Environmental Health Consultation Response

To	Hannah Kersley
Date	20-01-2026
Planning Ref	LU/250/25/RES
Site Description	Street Record Anderson Way Wick West Sussex
Date of Application	2025-12-10 00:00:00
Category	Reserved Matters
Recommendation	<p>No Objection</p> <p>No Objection — with conditions</p> <p>Objection</p> <p>Holding Objection</p>

Proposed Ground Floor Plan scale 1:100 @A1

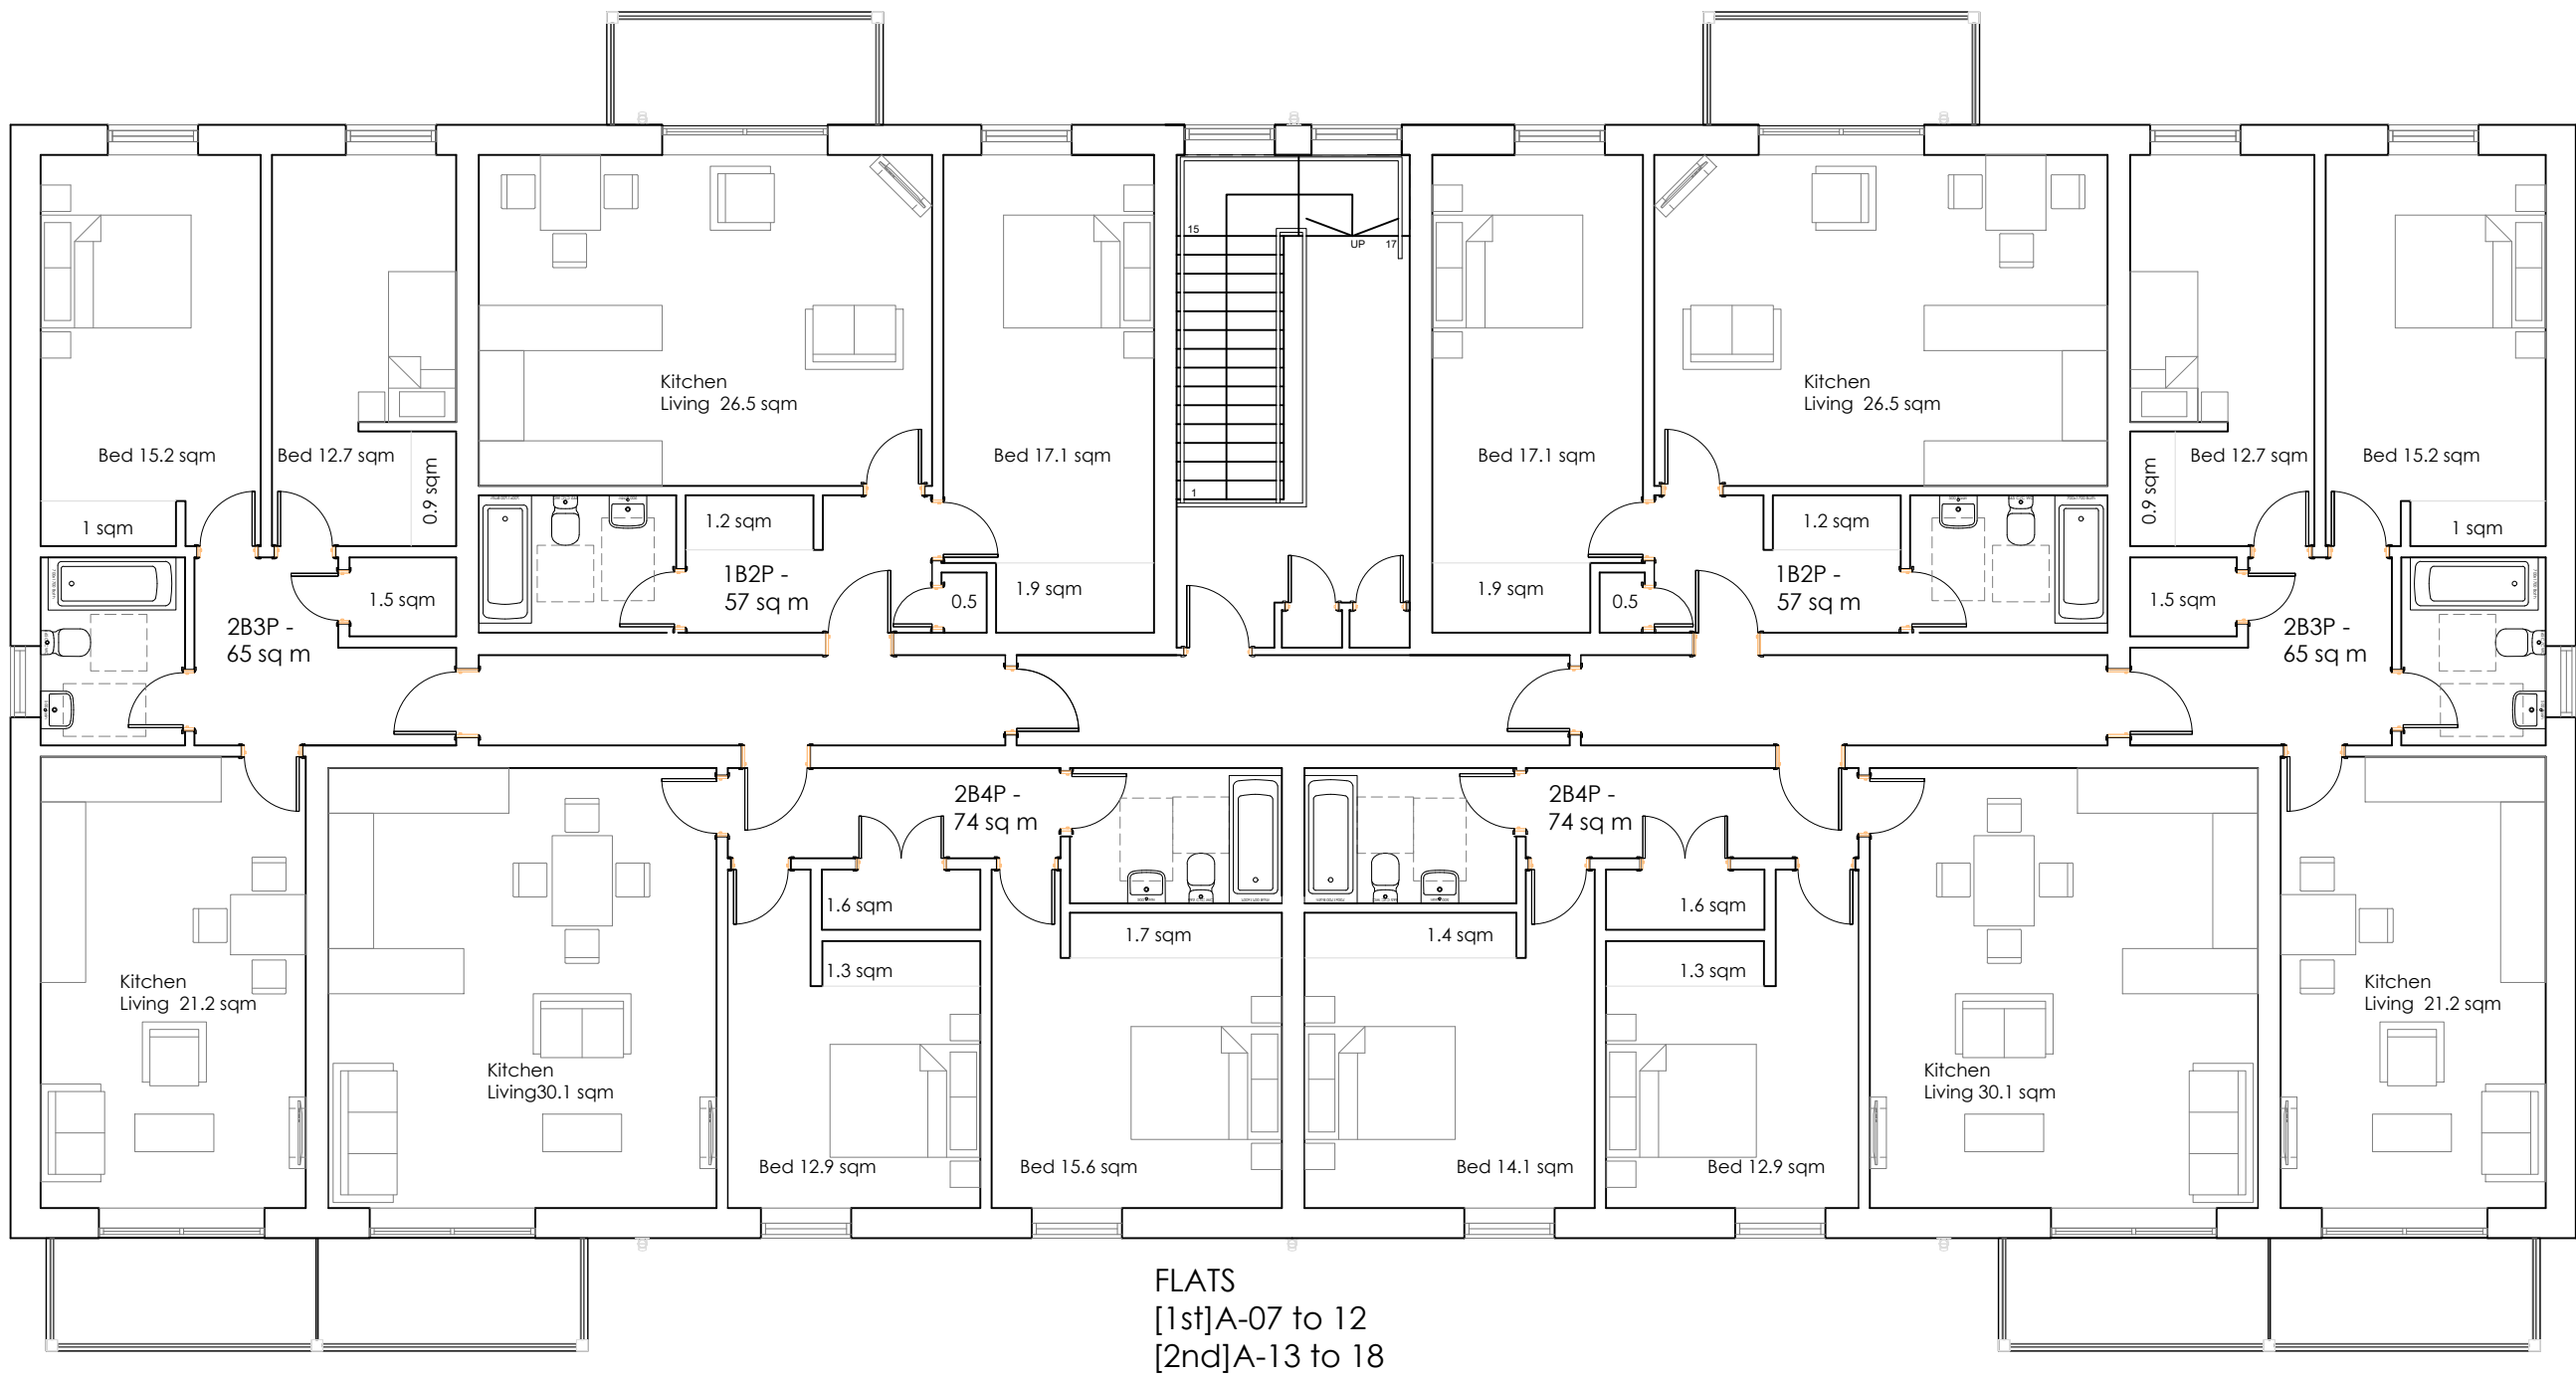
One area that we need further information on which does not seem to of been discussed, is the potential noise impact from new retail, and community use properties on the accommodation above?
